Gatwick Airport Northern Runway Project

Response to the Examining Authority's Written Questions
(ExQ2) – Historic Environment

Application Document Ref: 10.56.8

PINS Reference Number: TR020005

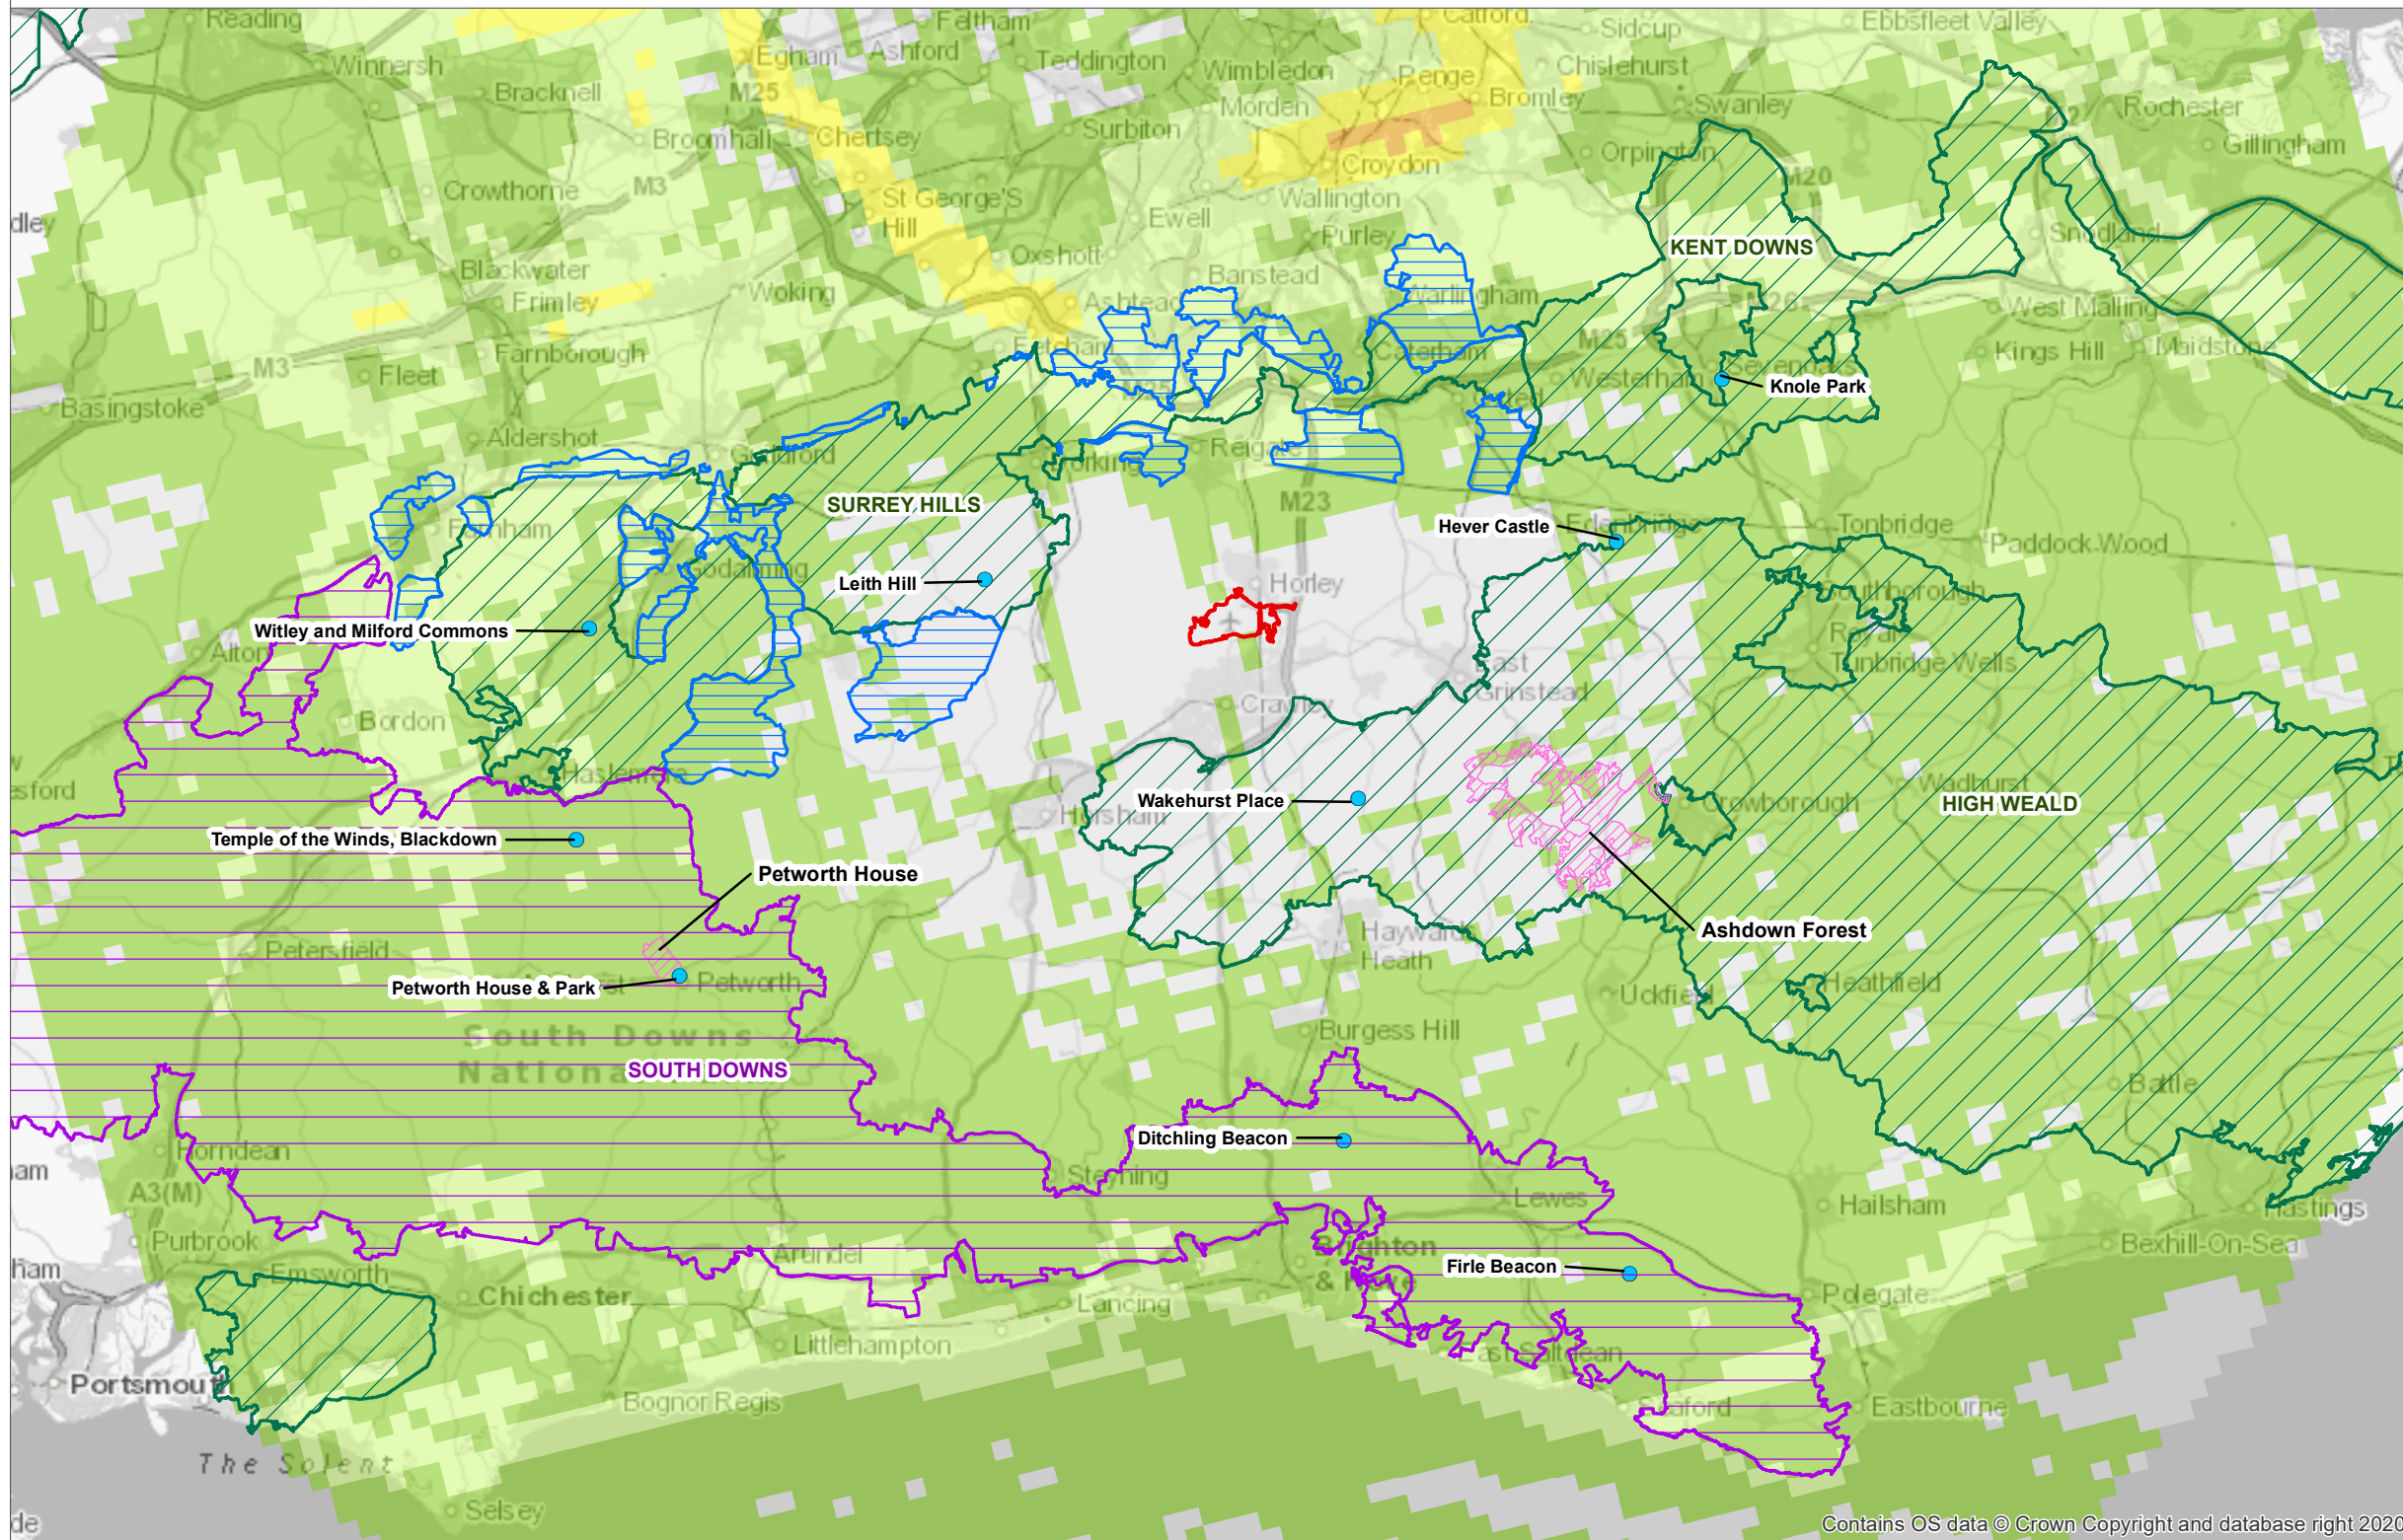
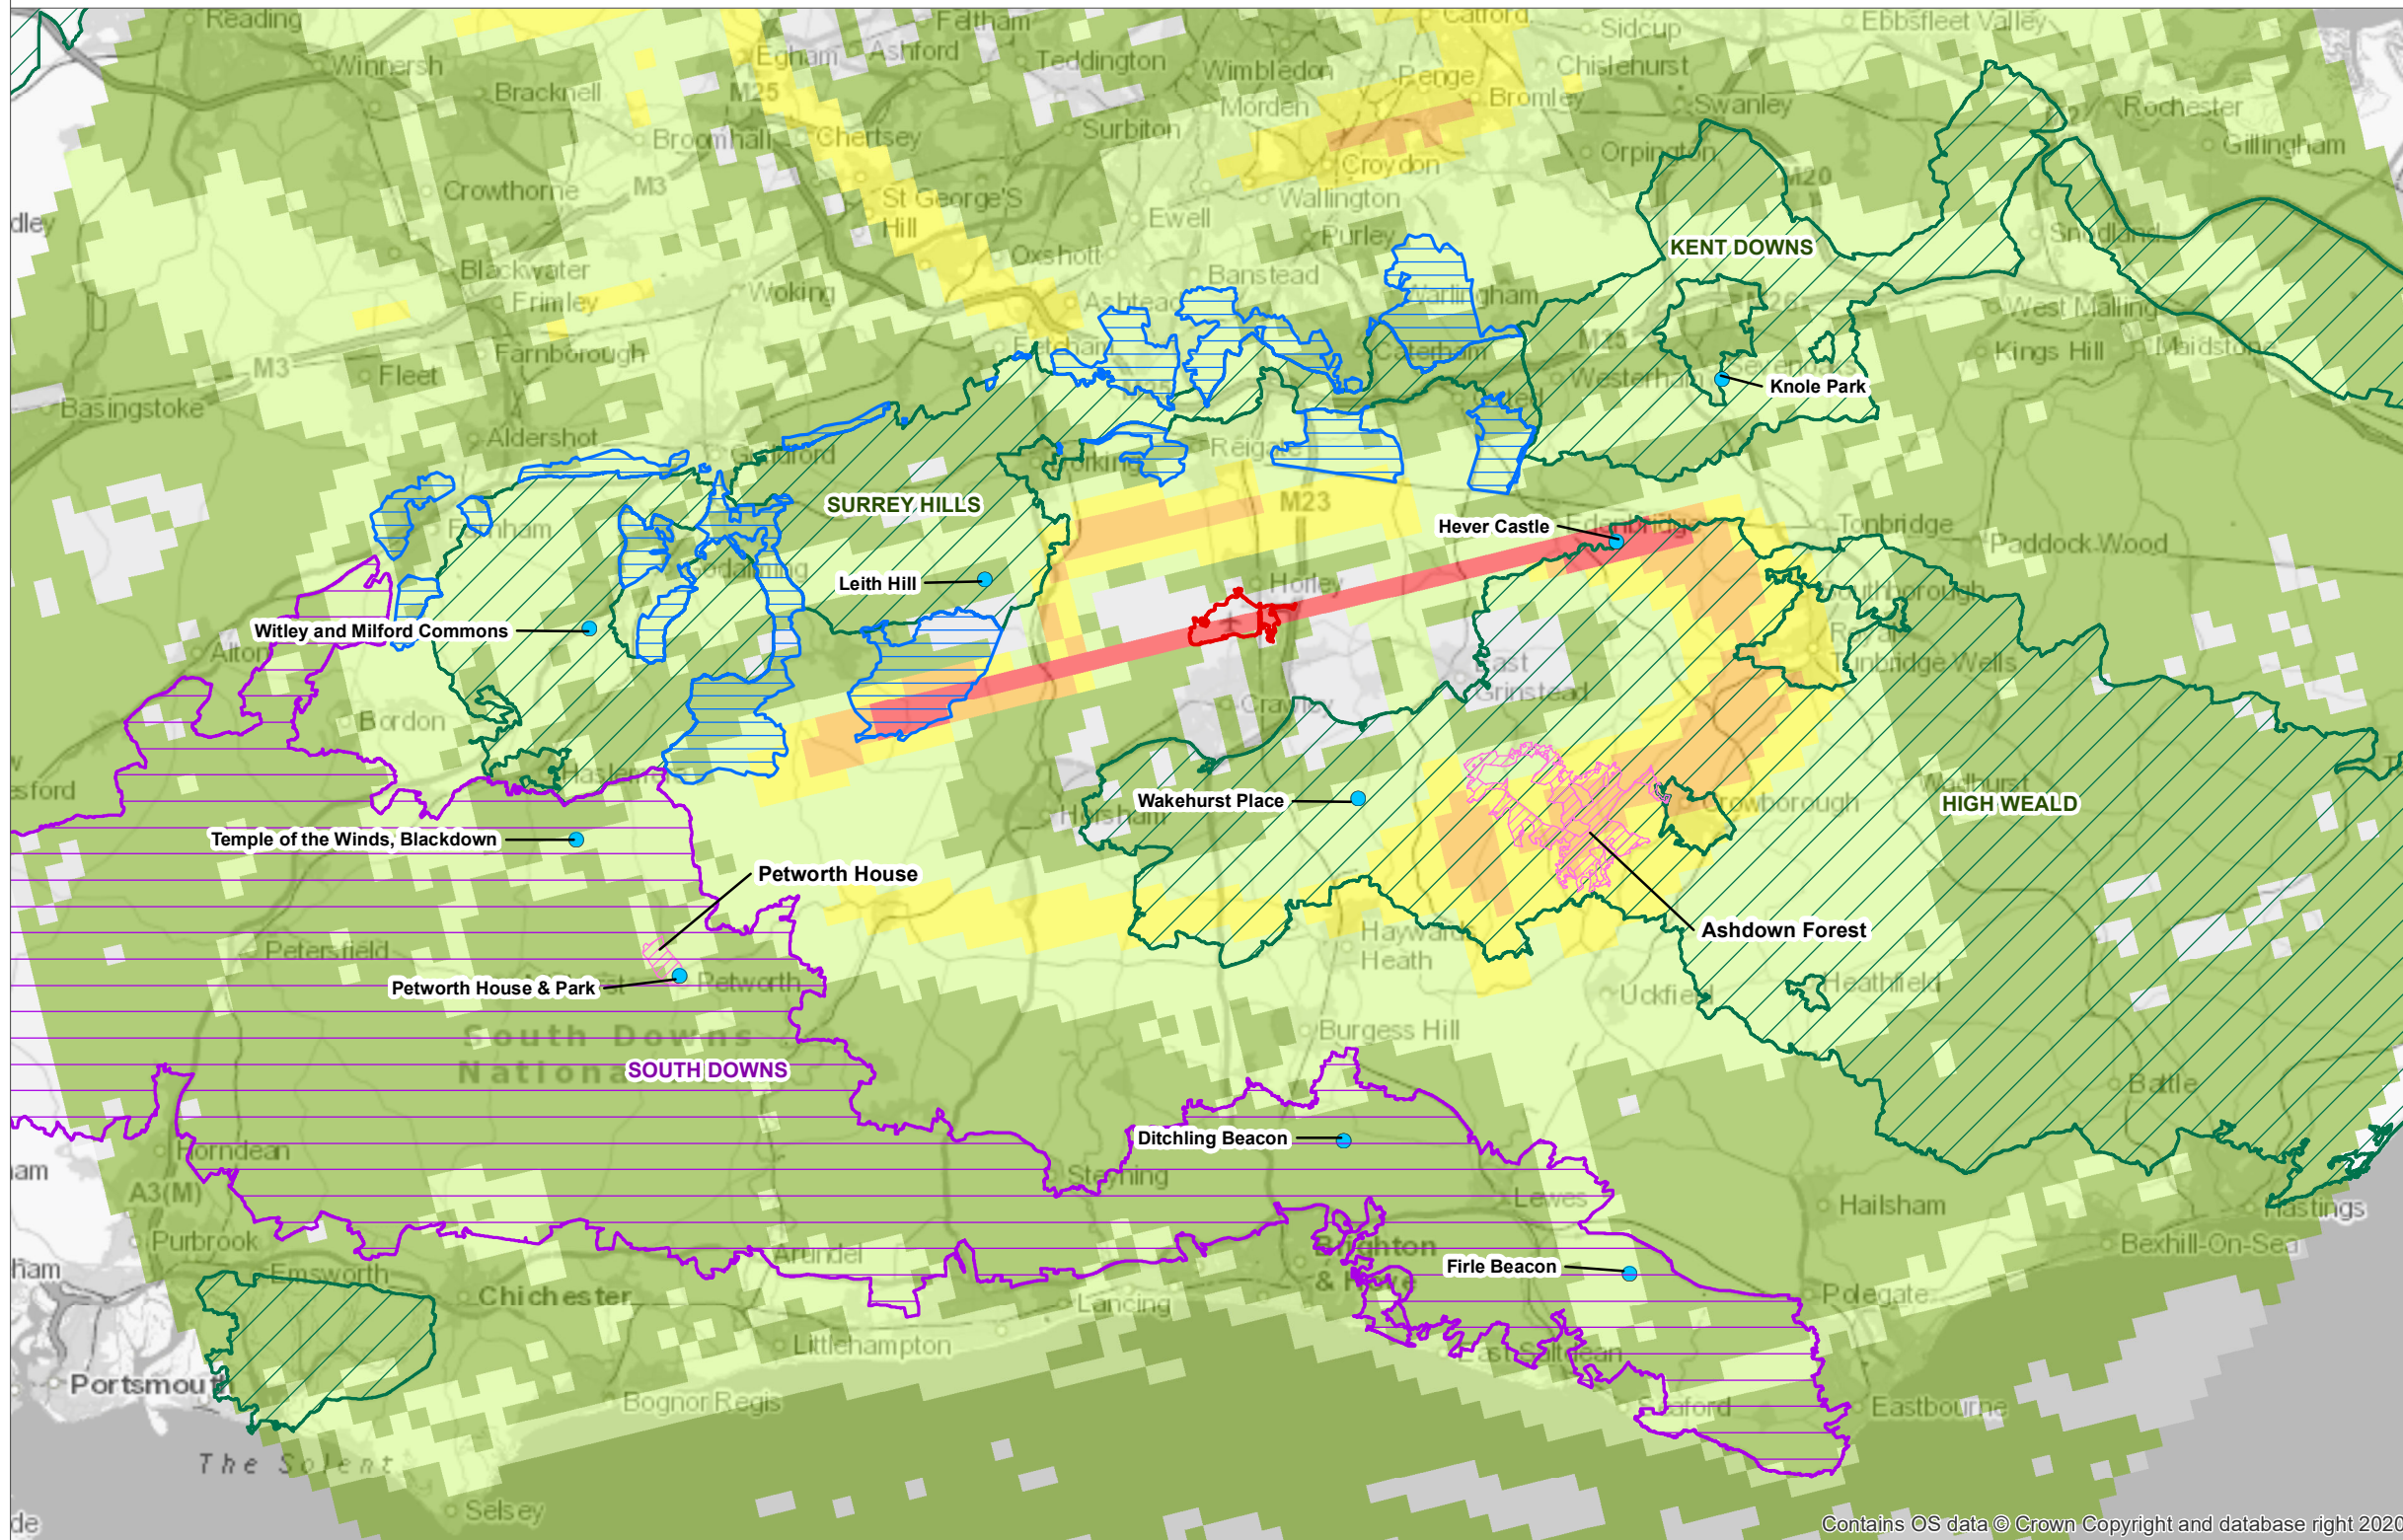
ExQ1	Question to:	Question:
HISTORIC ENVIRONMENT		
HE.2.1	Gatwick Aviation Museum	<p>Loss to the Gatwick Aviation Museum</p> <p>Your RR [RR-1496] states that any compulsory purchase of the land occupied by the museum would result in the loss of historic and educational resources to the nation.</p> <p>Please provide further details regarding such loss and confirm whether your previous comments are still valid.</p>
		N/A – this question is not directed at the Applicant.
HE.2.2	Applicant	<p>Hever Castle</p> <p>Provide clarification over the likely numbers of flights and ratio of such flights (arrivals and departures) likely to overfly Hever Castle as a result of the Proposed Development.</p>
		<p>ES Chapter 14: Noise and Vibration [APP-039] Table 14.12.1 provides estimates of summer season daily (24 hour) overflights including at Hever Castle, as follows:</p> <ul style="list-style-type: none"> • 2019 baseline - 309 • 2032 baseline - 325 • 2032 with Project – 389. <p>so showing a proportional increase of 20% overflights in the NRP scenario.</p>

<p>The overflight assessment considers all overflights, arrivals and departures, up to 7,000ft above local ground level from all airports. For the noise assessment (see ES Chapter 14: Noise and Vibration [APP-039]) arrivals and departures are modelled differently to compute total noise levels, but for the overflights assessment, which is not a noise assessment, the distinction is not necessary. At Hever Castle, the vast majority of overflights on an average summer day will be arrivals from the roughly 70% of days when the airport operates all flights in a westerly direction with far fewer departures on roughly 30% of days when the airport operates all flights in an easterly direction and when most departures turn before reaching Hever Castle. The increase in departure and arrivals overflights as a result of the NRP is expected to be 20% and the flight paths flown in this area will not change. The general orientation of flights are illustrated in Figures 8.6.3 to 8.6.7 of the ES Landscape, Townscape and Visual Resources Figures [REP2-007].</p>
